### **Final Report - Corrections Required** **Application No. DEPN-23-0002**

**Description : proposing to build (4) 3-story apartment buildings with clubhouse and pool**

**Document Filename : VV-DP\_V4\_8-30-23**

**DEVELOPMENT PLAN
STORM SYSTEM**

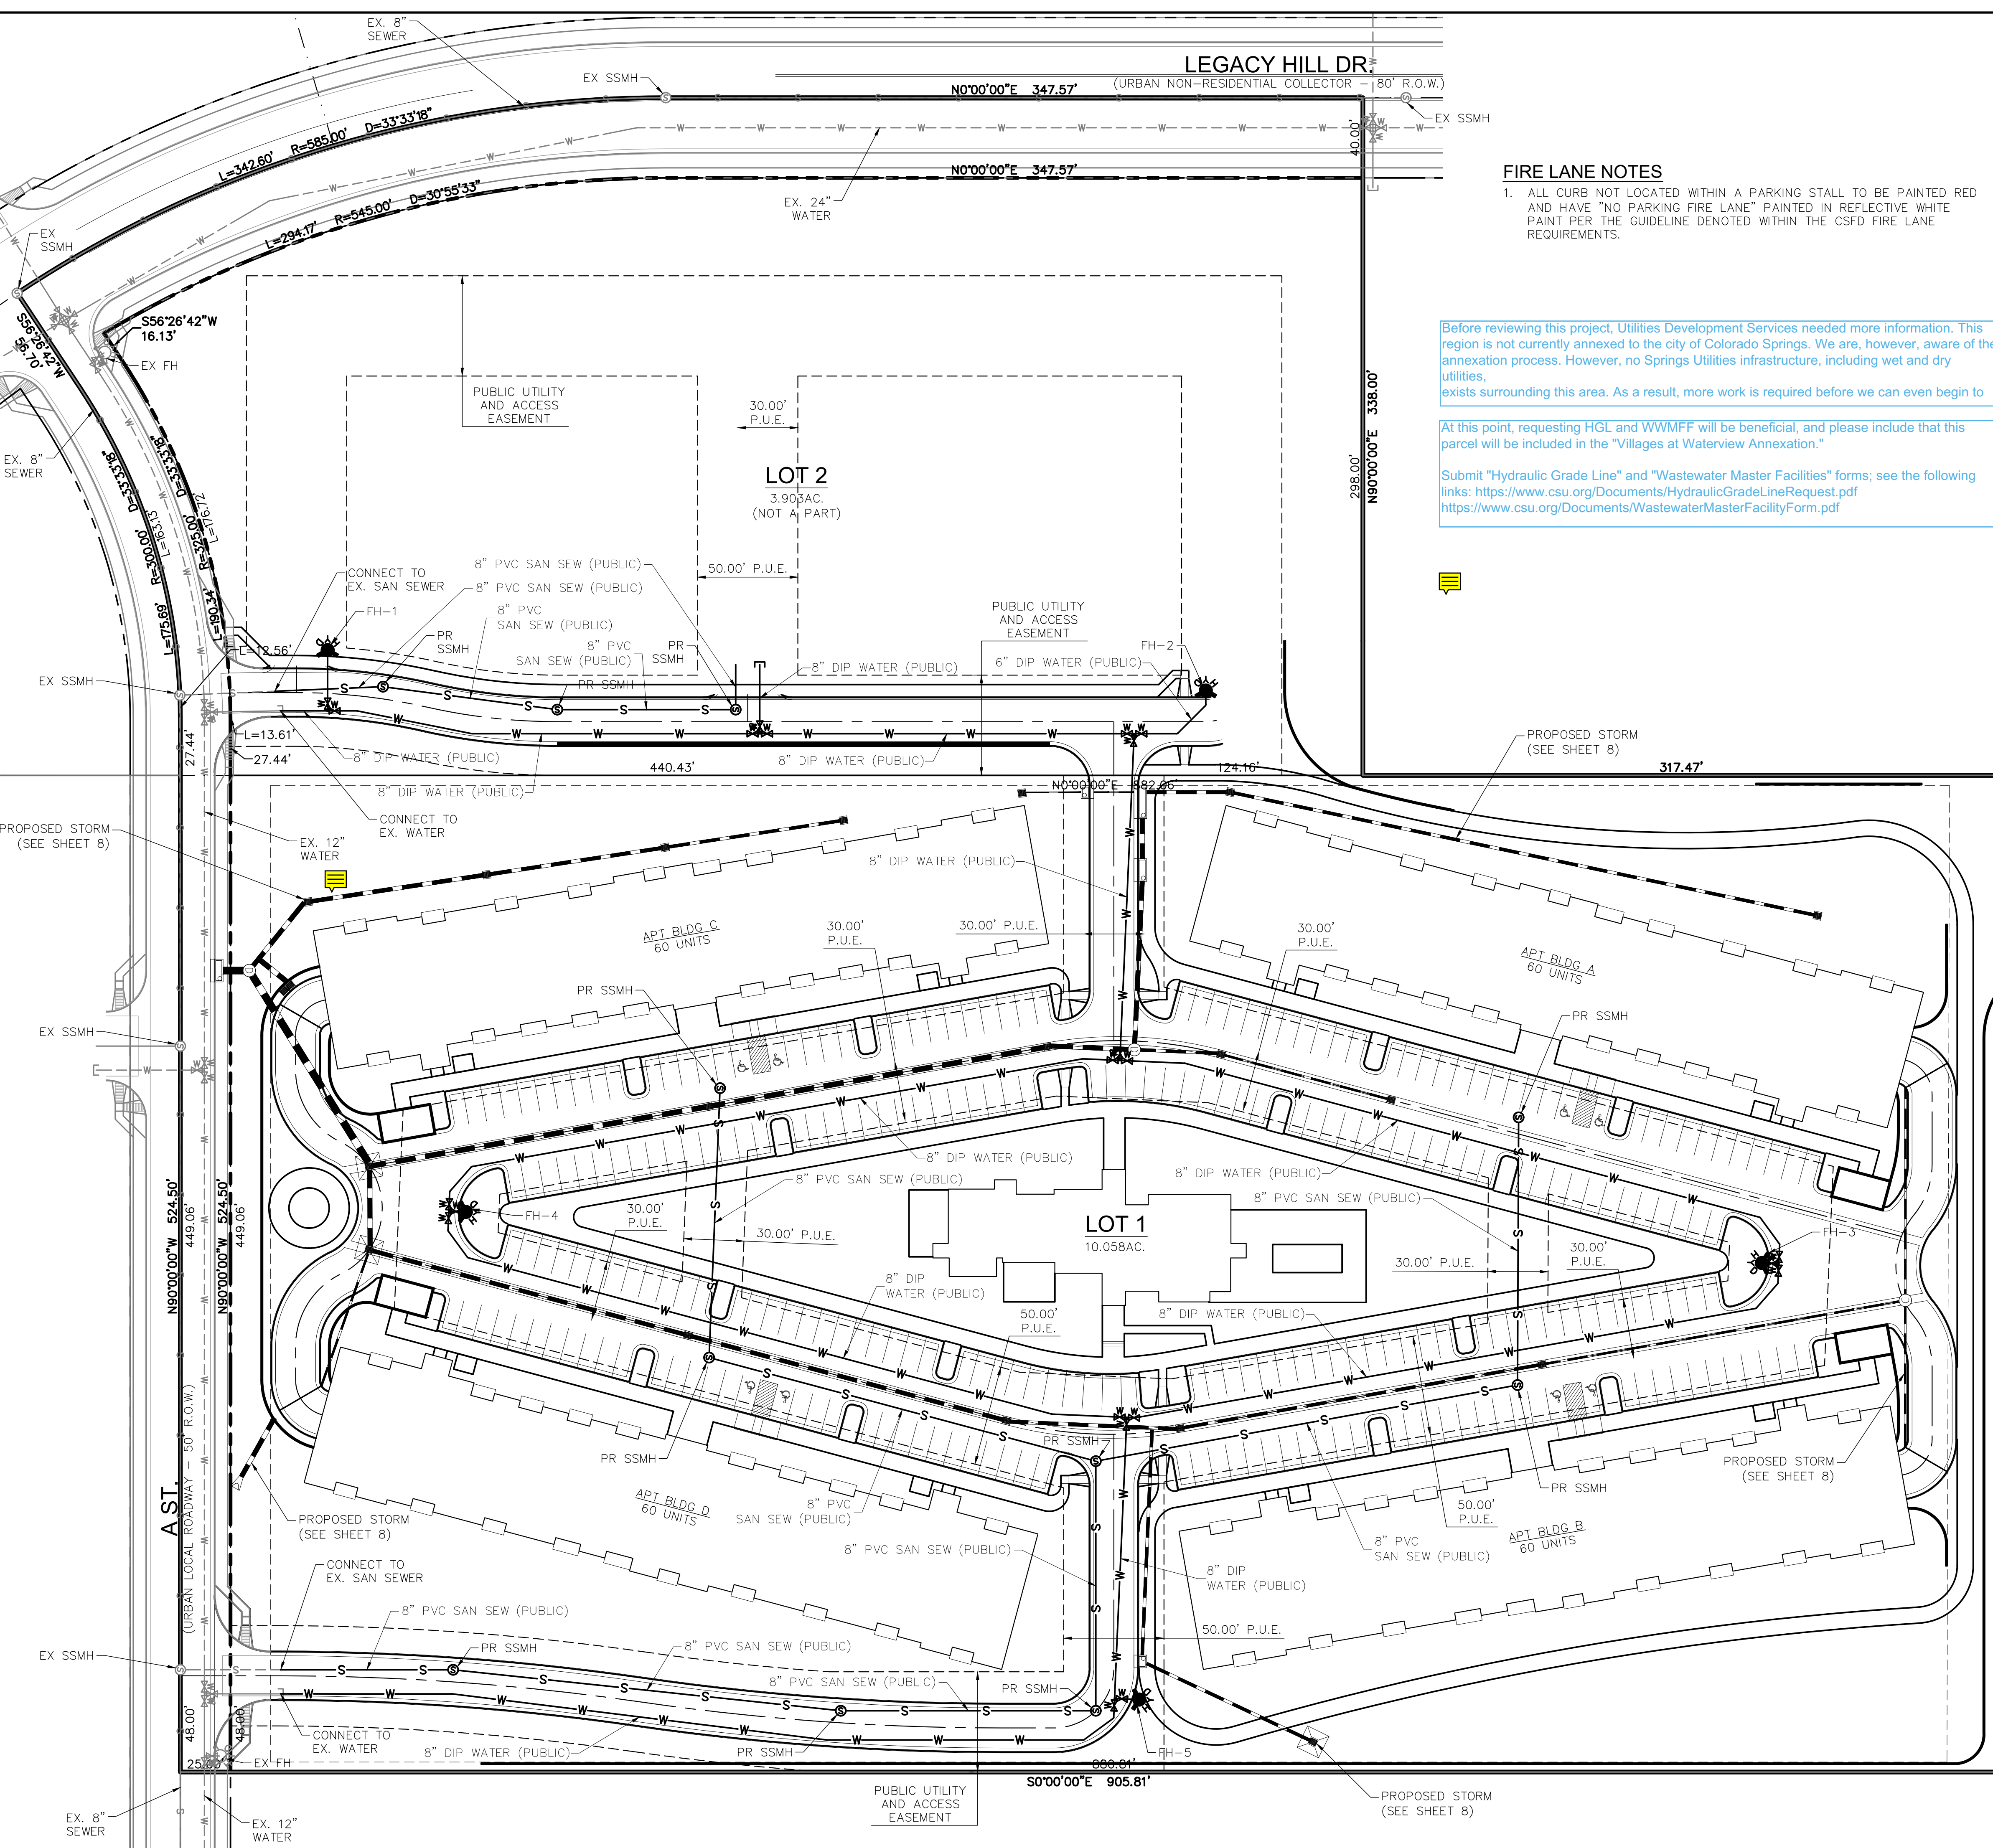
153	10	Jonathan Scherer : City Engineering - SWENT	Planned infiltration areas: Show the exact area from the FDR that is proposed on the Grading and Landscape plans. This needs to be shaded, textured coloured, etc. This is a global comment.
154	10	Jonathan Scherer : City Engineering - SWENT	33" and 27" pipes are not as common sizes. These are acceptable per the DCM, so this is an informational comment.
156	10	Jonathan Scherer : City Engineering - SWENT	There was no existing pipe shown here previously. Please verify this is correct.
143	11	Mike Gackle : Col Springs Utilities	An approved HGL response letter is required.
144	11	Mike Gackle : Col Springs Utilities	An approved WWMFF is required.
145	11	Mike Gackle : Col Springs Utilities	Final approval is contingent on the Annexation being approved.
146	11	Mike Gackle : Col Springs Utilities	Verify there is proper separation b/t FH & bldg.
147	11	Mike Gackle : Col Springs Utilities	Appears you will have a conflict with Storm and sanitary/manhole

SHEET **9** OF **35**

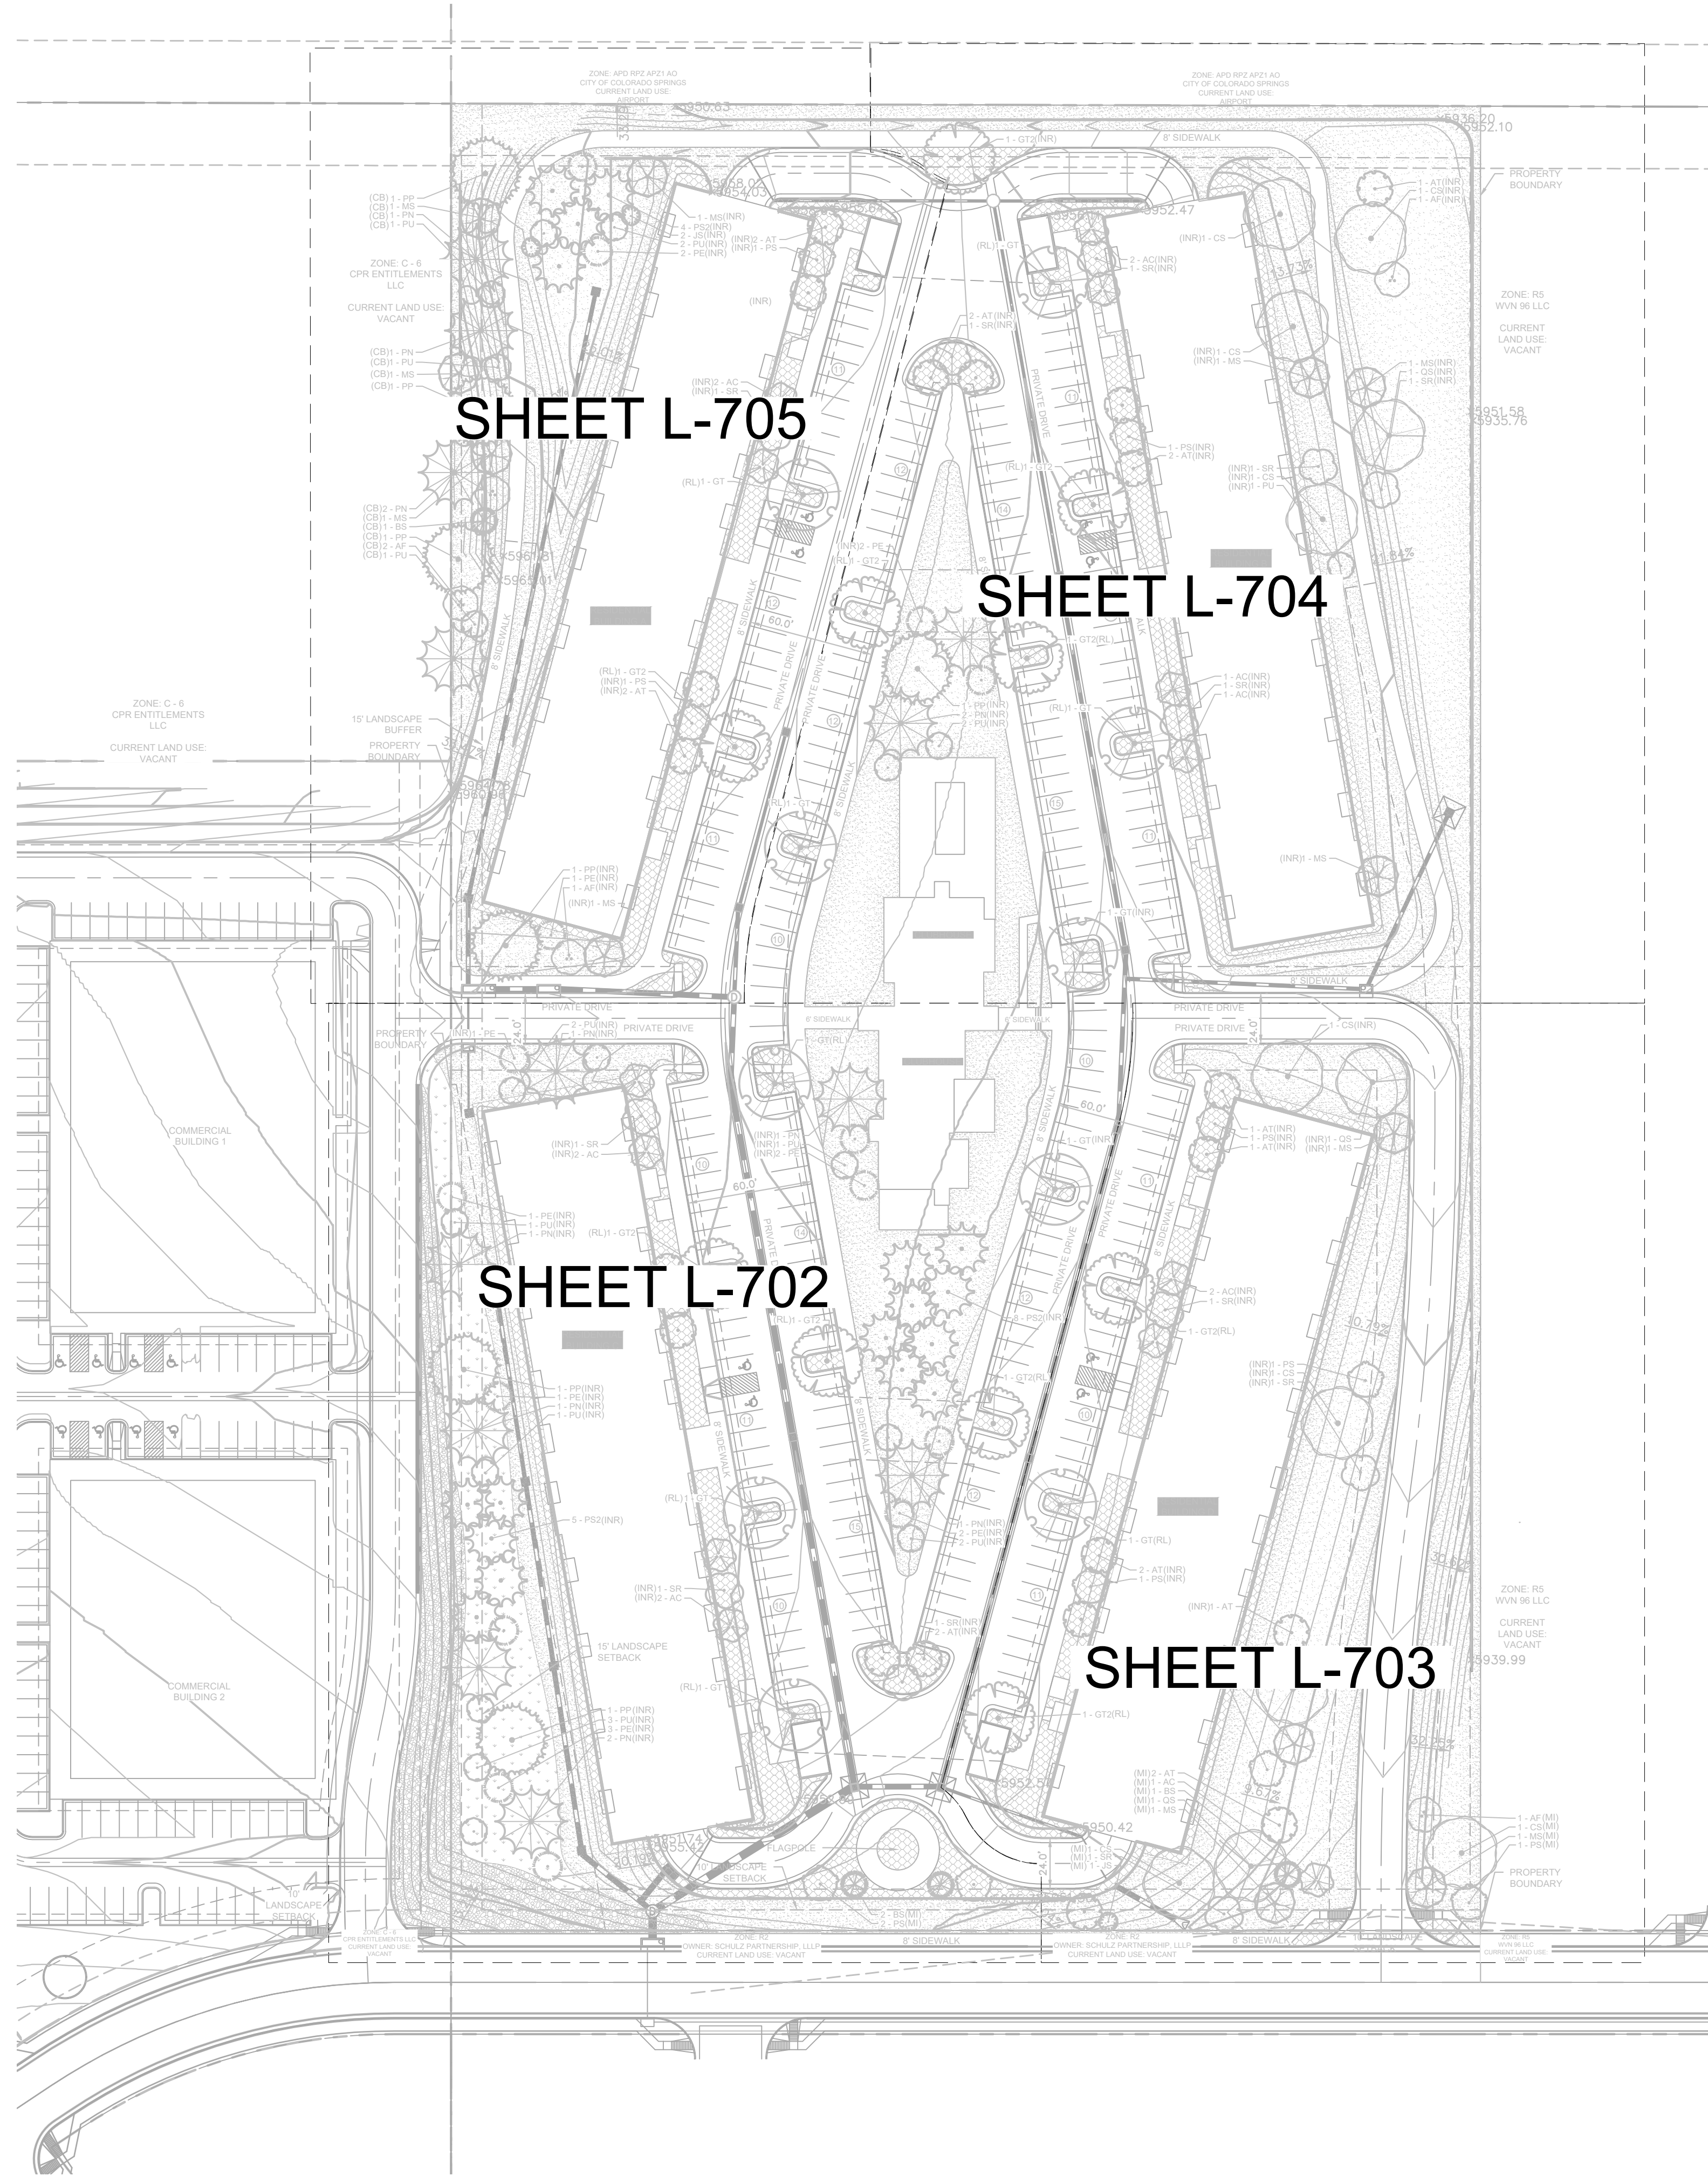
148	11	Mike Gackle : Col Springs Utilities	If the Fire Hydrants are not in an easement are they going to be Private?? If Public change the easement lines on this plan and the Plat.
149	11	Mike Gackle : Col Springs Utilities	Show and label all proposed services.
150	14	Mike Gackle : Col Springs Utilities	Show and label propose sanitary main
151	14	Mike Gackle : Col Springs Utilities	Show and label proposed water and wastewater mains and services on all Landscape Plans.
137	1	Caroline Miller : Planning	Please revise note to state: 'In reference to COPN-22-0002, PLDO obligations for this parcel will be met by fees in lieu of land dedication.'
138	1	Caroline Miller : Planning	CDI: Citywide Development Impact Fees for Police and Fire apply to all new and redeveloped residential and nonresidential development. This development is applicable to CDI and an estimate of PLDO, School, and CDI fees have been uploaded to this file and will be due at time of building permit.
